Advice on Response to Submissions – State Significant Development

Proposal: Mixed use development with infill affordable housing - 160 Oxford Street, Paddington

Major Project reference: SSD-97528708

Overshadowing diagrams on 21 June. The shadows from the proposal are shown in brown and those from the trees are shown in purple

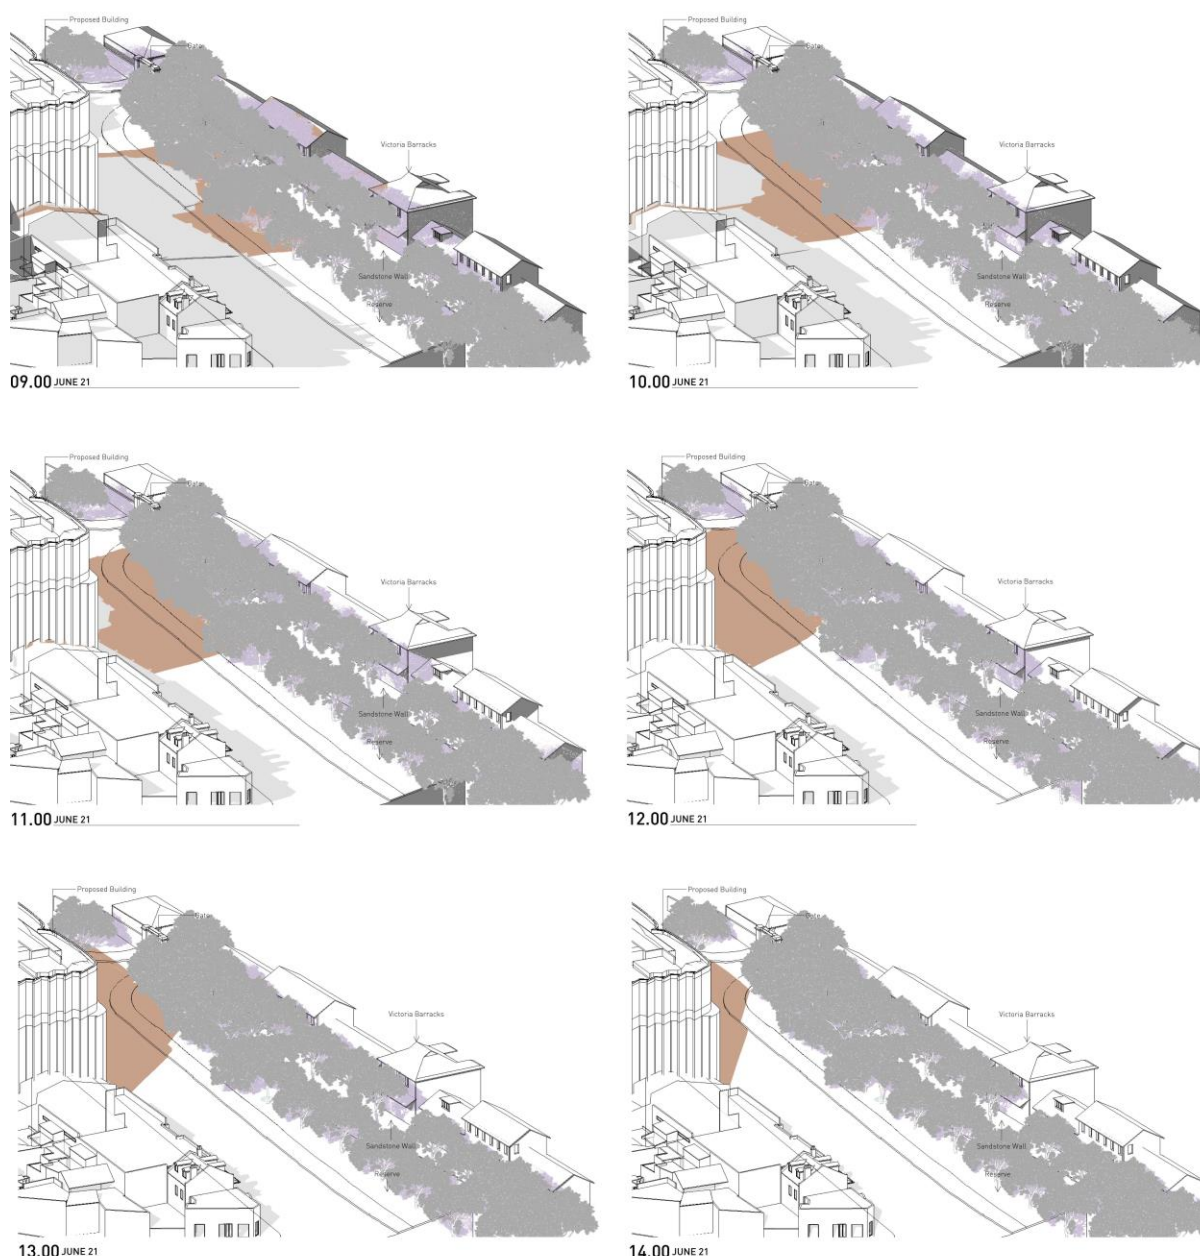
- Part of the barracks' front wall and buildings 95 and 96 would be overshadowed on mid-winter mornings until approximately 12pm. Heritage NSW notes that existing trees in the adjacent reserve currently cast shadows across these elements in mid-winter, but the shade from the trees is dappled rather than a blanket shadow that would result from the SSD.

- Heritage NSW notes the above assessment but considers that additional overshadowing of the exceptionally significant Victoria Barracks by the SSD, particularly the barracks' frontage to Oxford Street, would detract from the significance of the place. We recommend that the SSD be amended to avoid any overshadowing of Victoria Barracks.
